**Our ref:** XA/2025/100357/01-L01

**A46 Coventry Junction (Walsgrave) – Development Consent Order Application**

**Examination: Issue Specific Hearing 1 Action**

We have reviewed the Issue Specific Hearing 1 Action Points (dated 8 May 2025) and our comments are provided in the table appended to this letter.

- E2.1 DRAINAGE FEATURE REFER TO DRAINAGE DESIGN

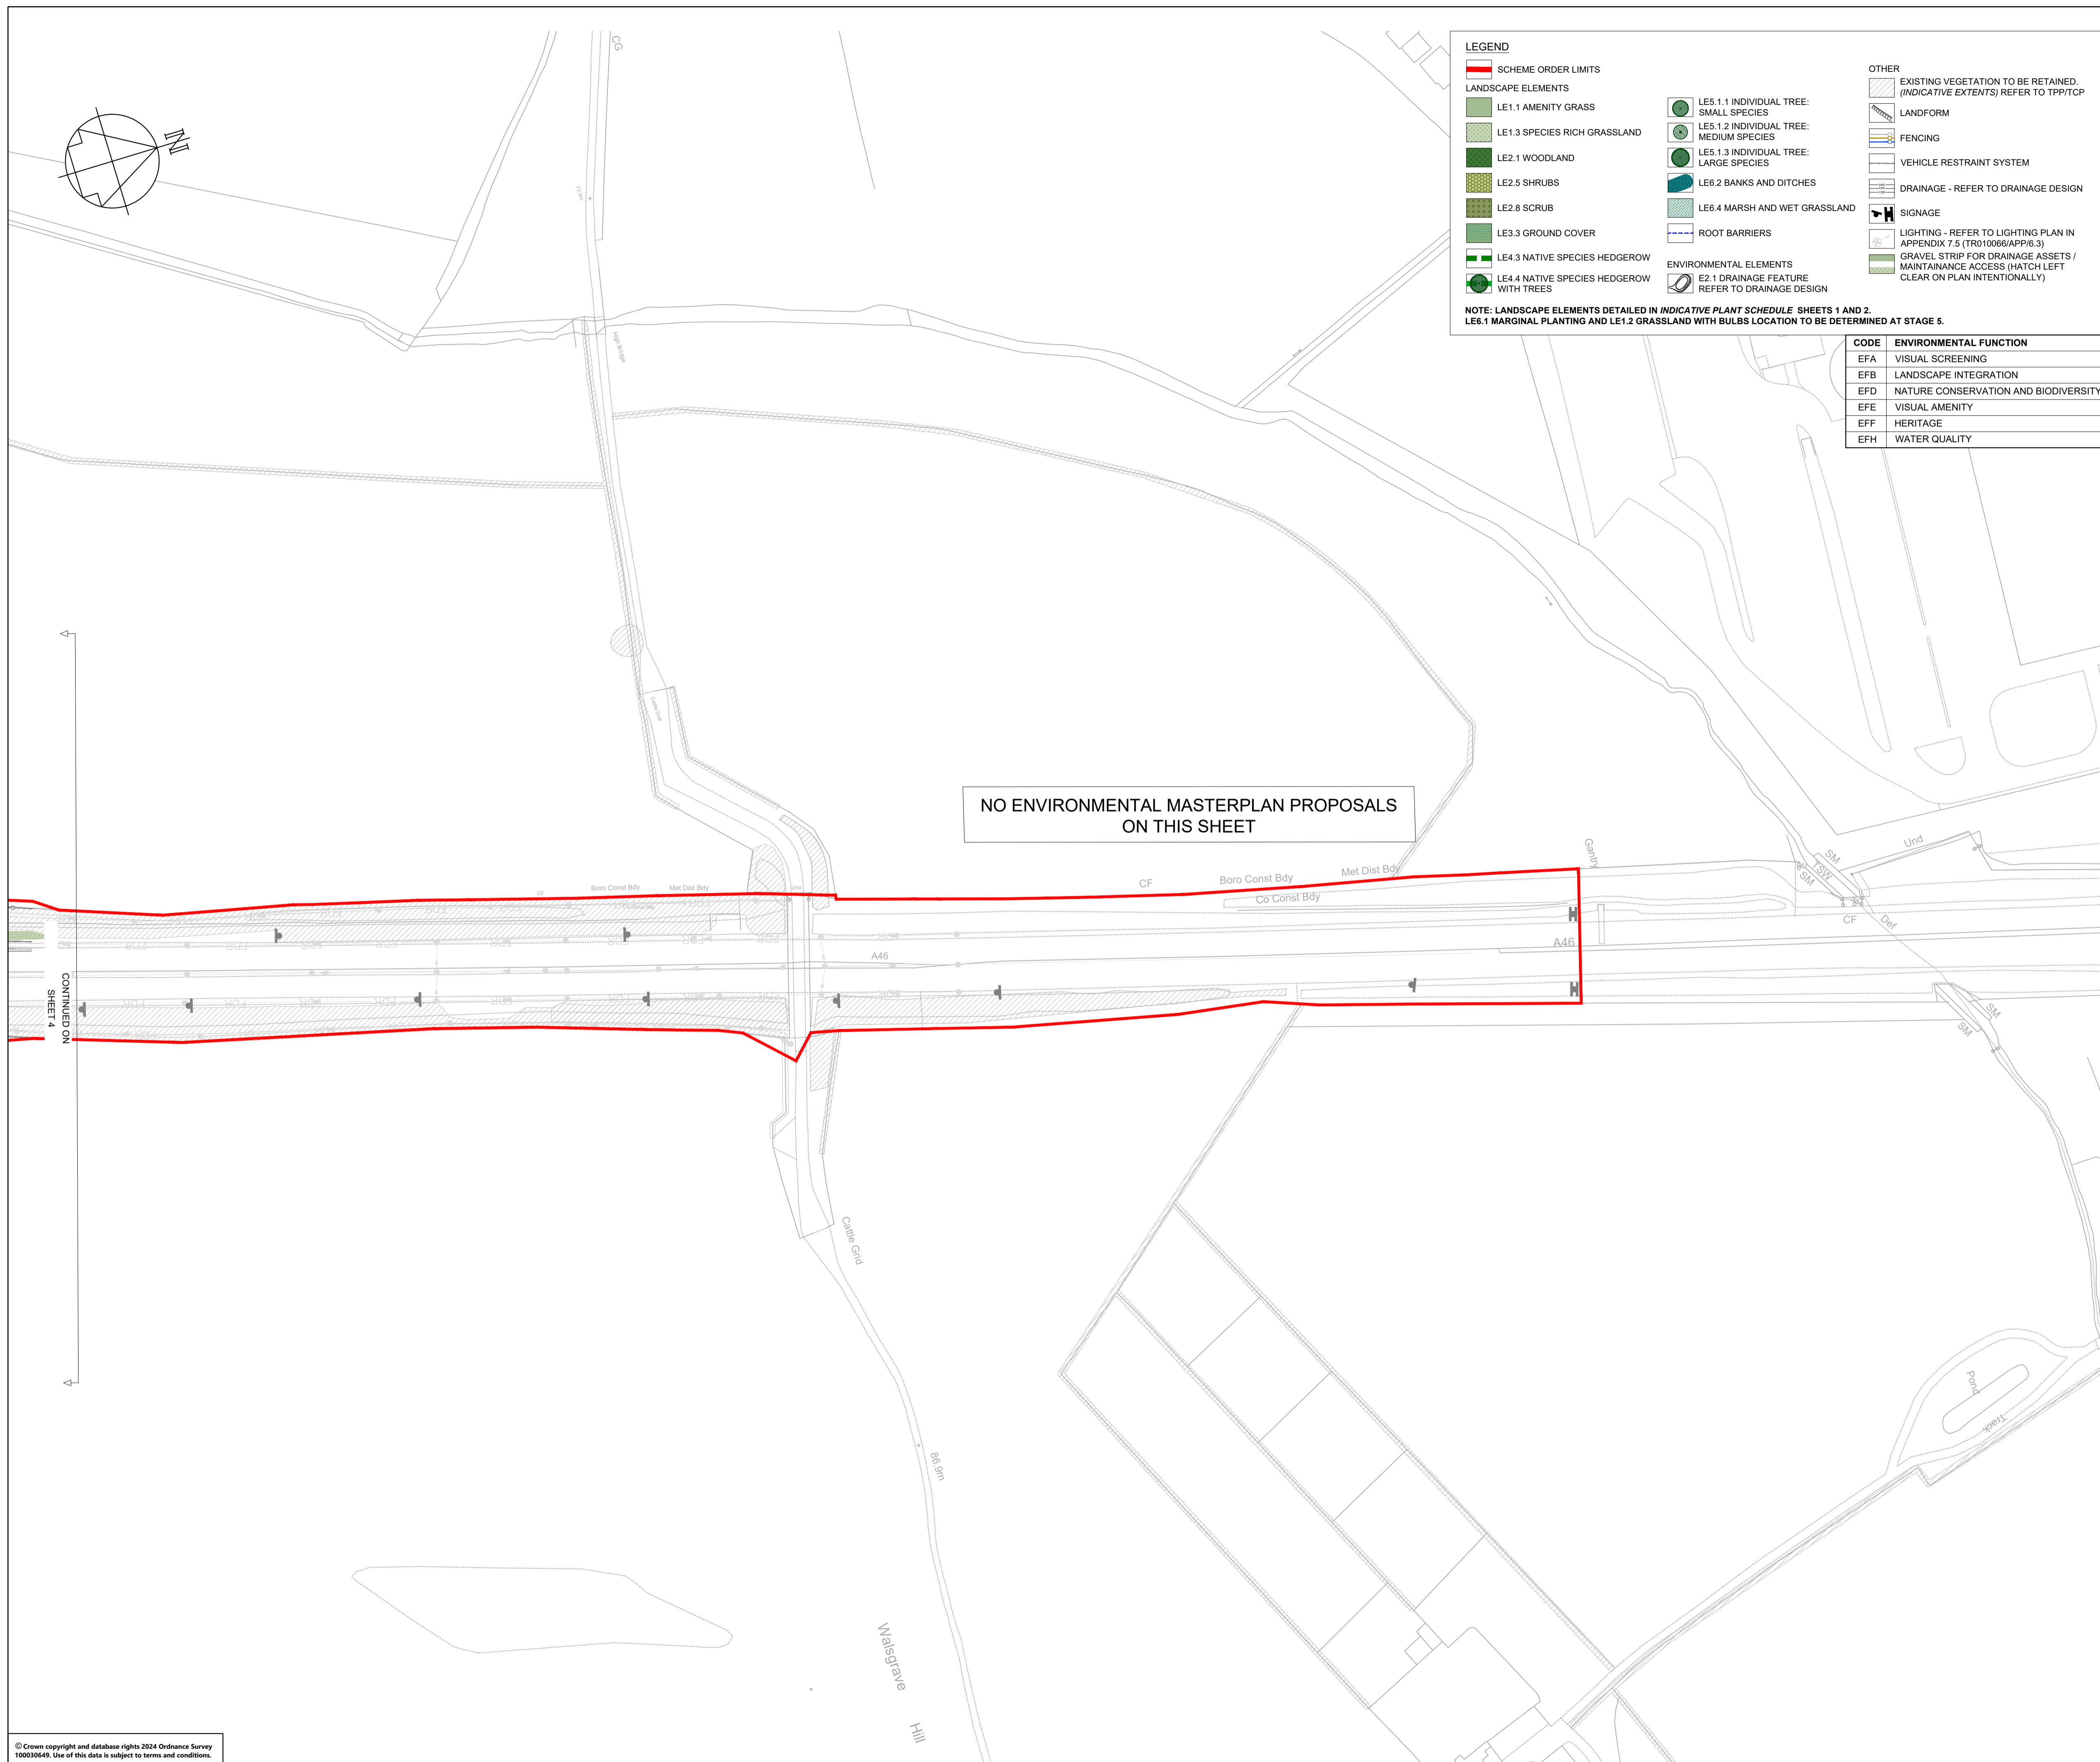
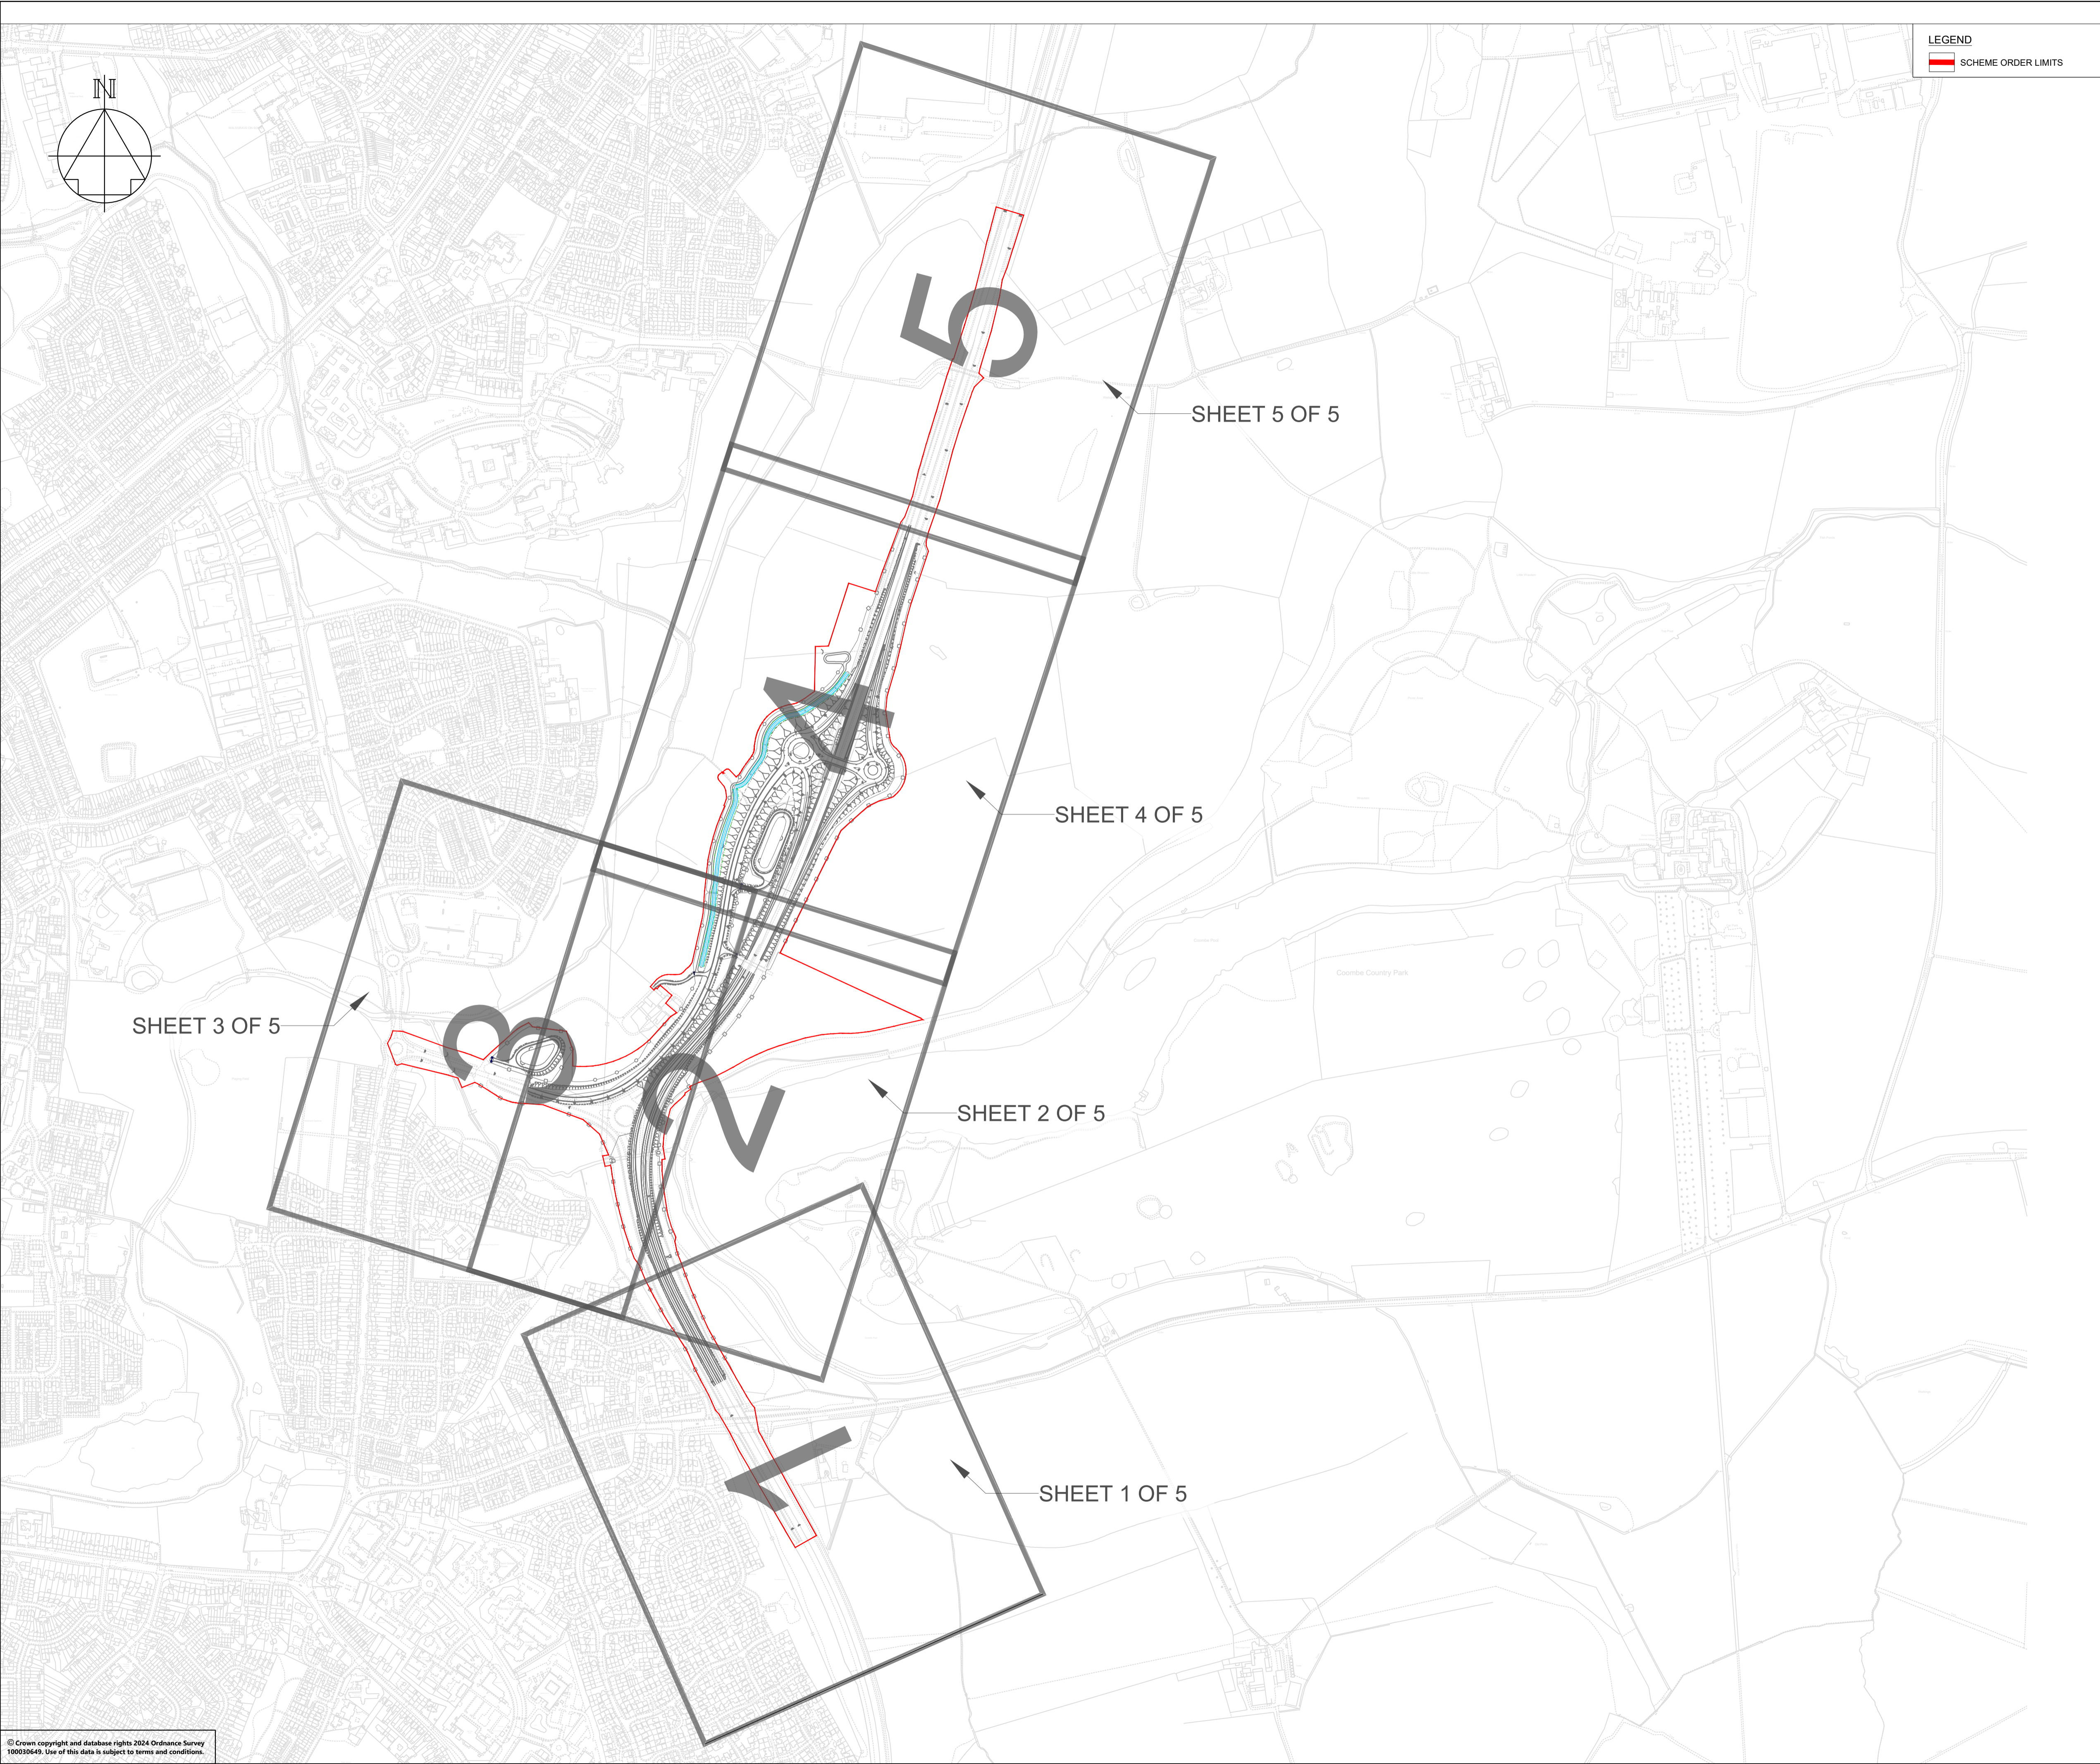
| No | ACTION  | RESPONSE   |
|----|---|--|
|    | What is the Environment Agency's position on the Applicant's proposals to protect and enhance watercourses and the development of new habitats in proposed detention basin? | <p>The Environment Agency (EA) approves of the proposed measures outlined in Figure 2.4, to plant scrub, hedgerows and woodland around the new detention basin, to improve connectivity between the waterbody and the surrounding landscape. We also approve of the native seed and plug mixes chosen to enhance the basin (LE6.4, page 12) and to enhance the riparian edges of the watercourses (LE6.2, page 12). However, we would also recommend adding rushes (e.g. <i>Juncus</i> sp.) to the species lists.</p> <p>In addition, further enhancements measures could be considered to make the detention basin and watercourses more attractive to wildlife by providing habitat variety if possible and practicable.</p> |
|    | Can the Environment Agency provide examples for the suitable and practicable enhancement for the watercourses and detention basin?  | <p>As a regulator, it would be inappropriate for us to outline exactly how the applicant should enhance any habitat on the site; however, we can provide the following examples:</p> <ul style="list-style-type: none"> <li>• The base could be designed with gently sloping earthworks that mimic naturalistic edges, which provide a variety of water depths. Planting will depend on how often the detention basin is expected to be wet throughout the year.</li> <li>• Temporarily wet areas such as at the top of slopes could be sown with wet-grassland species mixes.</li> <li>• Marshy/waterlogged areas such as near the outlet could be planted with emergent aquatic species.</li> </ul>                          |

|    |  | <ul style="list-style-type: none"> <li>• Flatter areas like the base could be planted with marginal aquatic species.</li> <li>• All species should mimic plant communities found within local wetland and marshy habitats. Planting would make the basin more appealing to species such as amphibians, invertebrates, birds and bats.</li> </ul> <p>Enhancement options for watercourses include the removal of physical modifications/artificial banks, the management of invasive non-native species and the retrofitting of mammal ledges to bridges/culverts.</p> |
